City of Portland, Maine - Building or Use Permit Application
 389 Congress Street, 04101 Tel: (207) 874-8703, Fax: (207) 874-8716

Permit No: 05-1397	Issue Date:	CBL: 342 B052
------------------------------	--------------------	-------------------------

Past Use: Vacant Land - Willow Knoll subdivision	Proposed Use: Single Family Home/ Move 2160 sq ft single Family Home on to lot add 20' x24 ' Garage	Permit Fee: \$453.00	Cost of Work: \$48,000.00	CEO District:
Proposed Project Description: Move 2160 sq ft single Family Home on to lot add 20' x24 ' Garage		FIRE DEPT: <input type="checkbox"/> Approved <input type="checkbox"/> Denied	INSPECTION: Use Group: Type	
		Signature:	Signature:	
PEDESTRIAN ACTIVITIES DISTRICT (P.A.D.)				
Action: <input type="checkbox"/> Approved <input type="checkbox"/> Approved w/Condition <input type="checkbox"/> Denied				
Signature:		Date:

Dept: Zoning **Status:** Approved with Conditions **Reviewer:** Ann Machado **Approval Date:** 10/24/2005
Note: 10/13/05 Left message with Dana. Need elevation plans, foundation plans & plans for garage. **Ok to Issue:**
10/20/05 Message w/Nick. Still questions on some dimensions.

# GARAGE

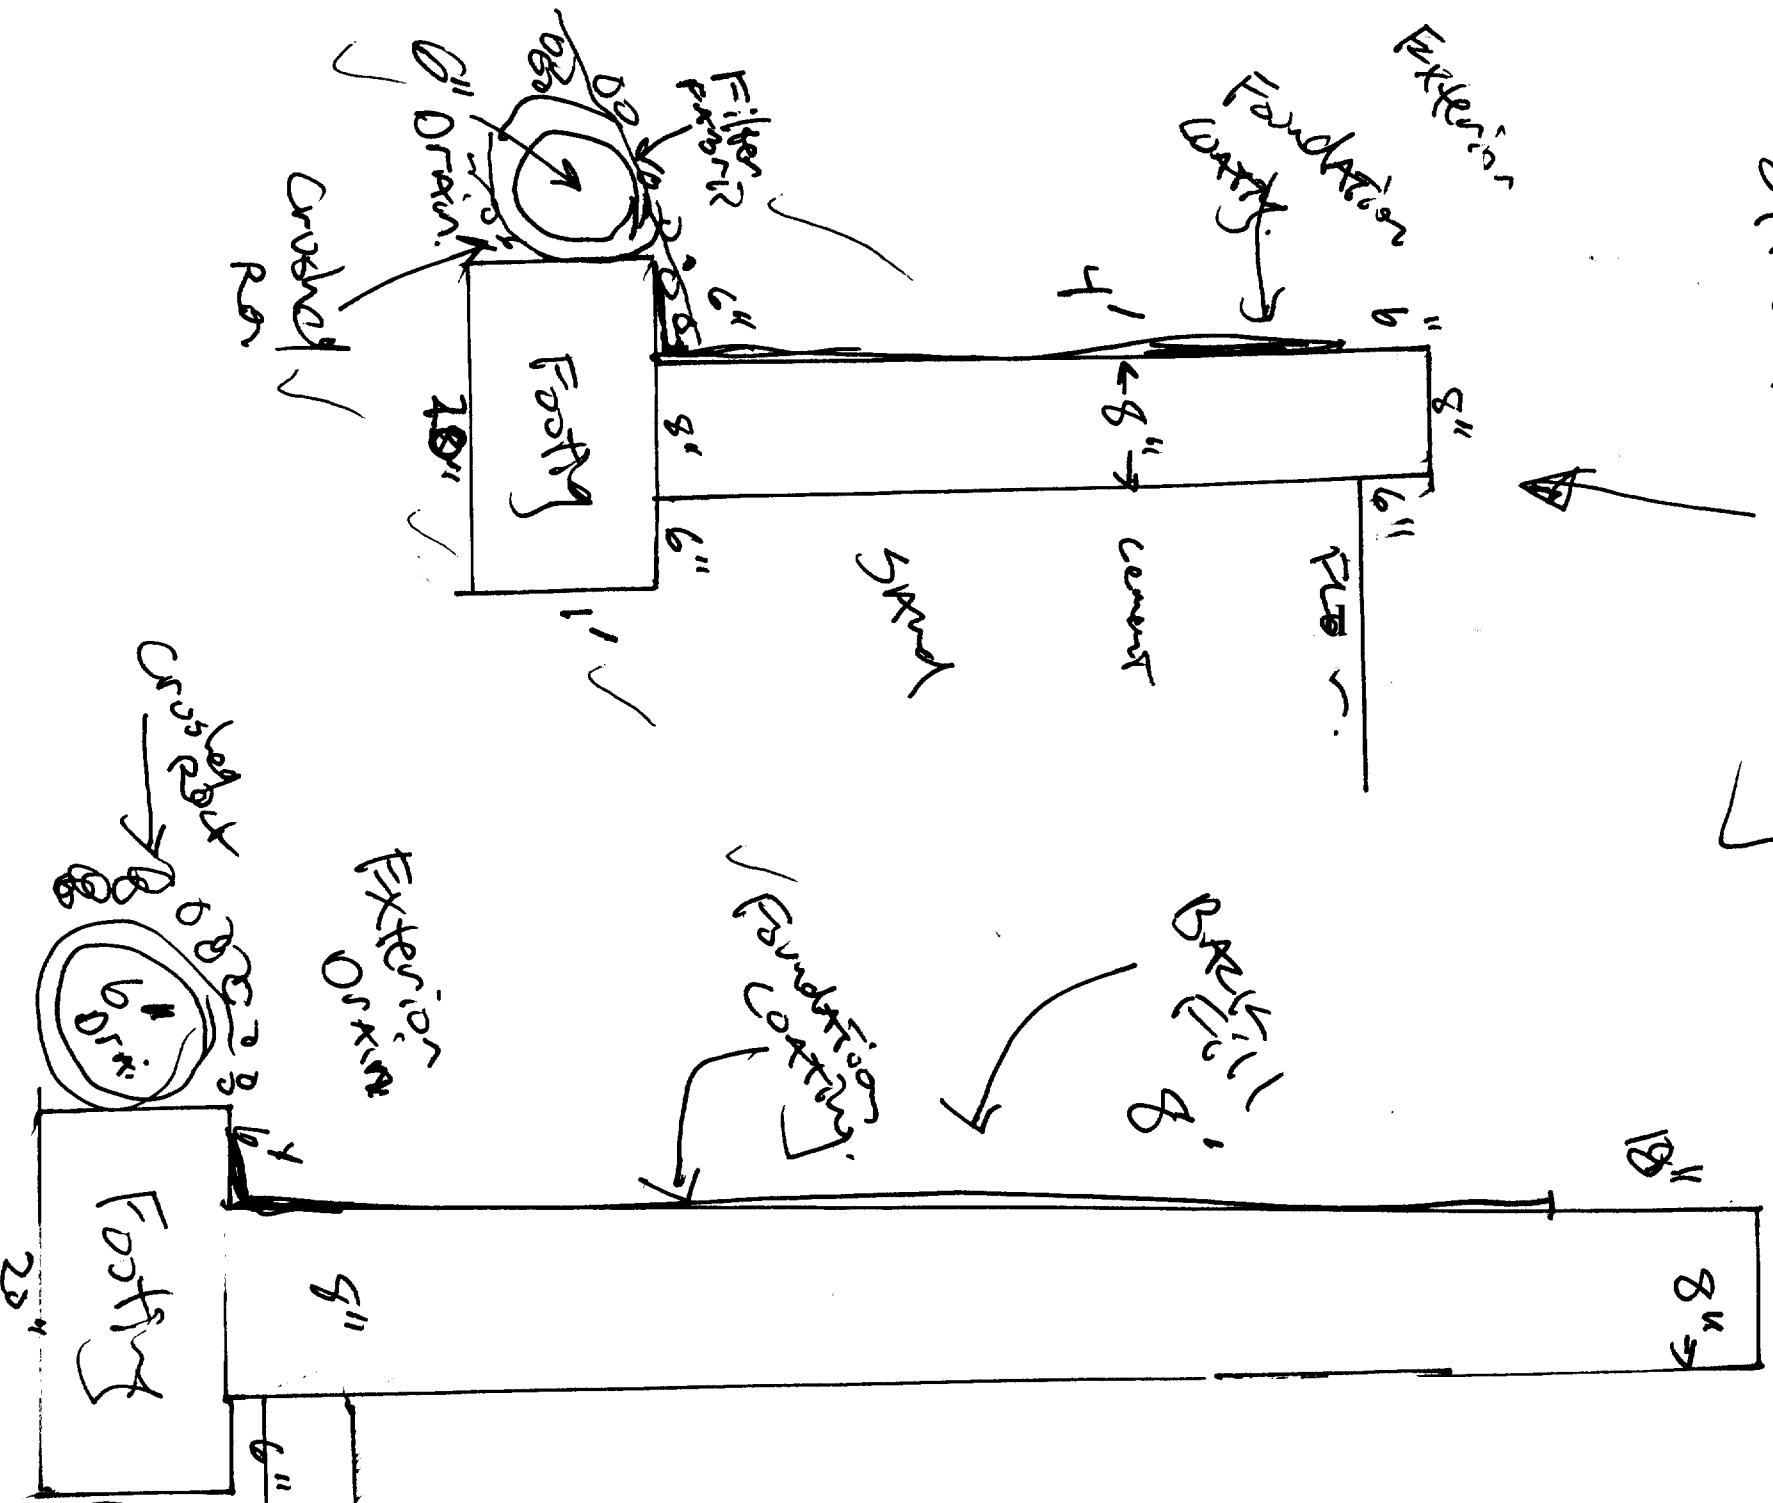
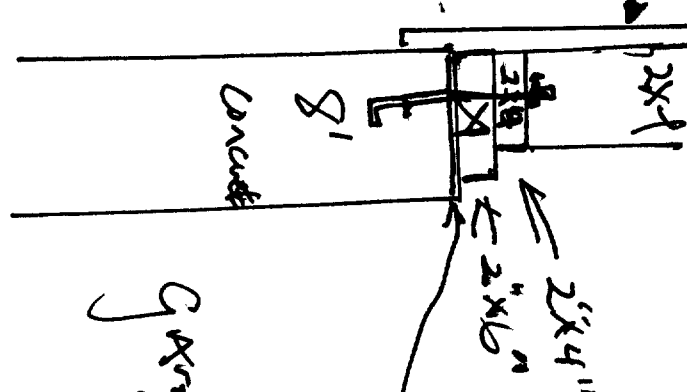
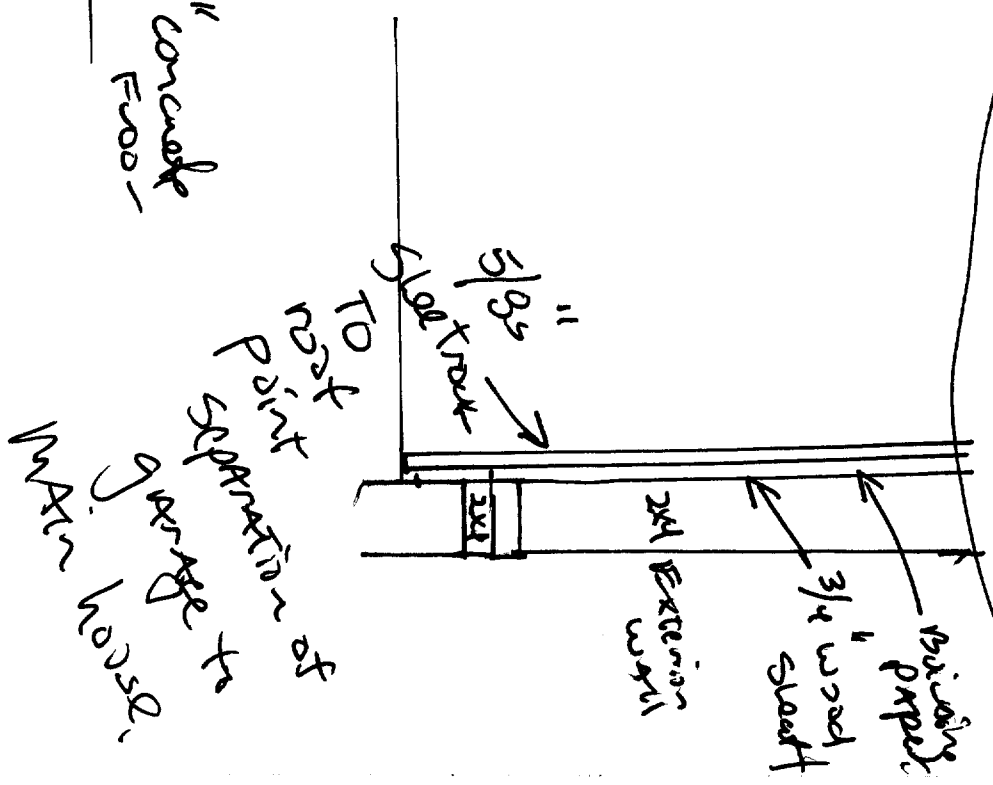
10/25/05-GG: received revised & approved site plan from Jay . /gg
10/25/05-tmm: need better foundation plan and better details on garage - left message w/builder.
10/25/05-tmm: faxed copy of review sheets to woner
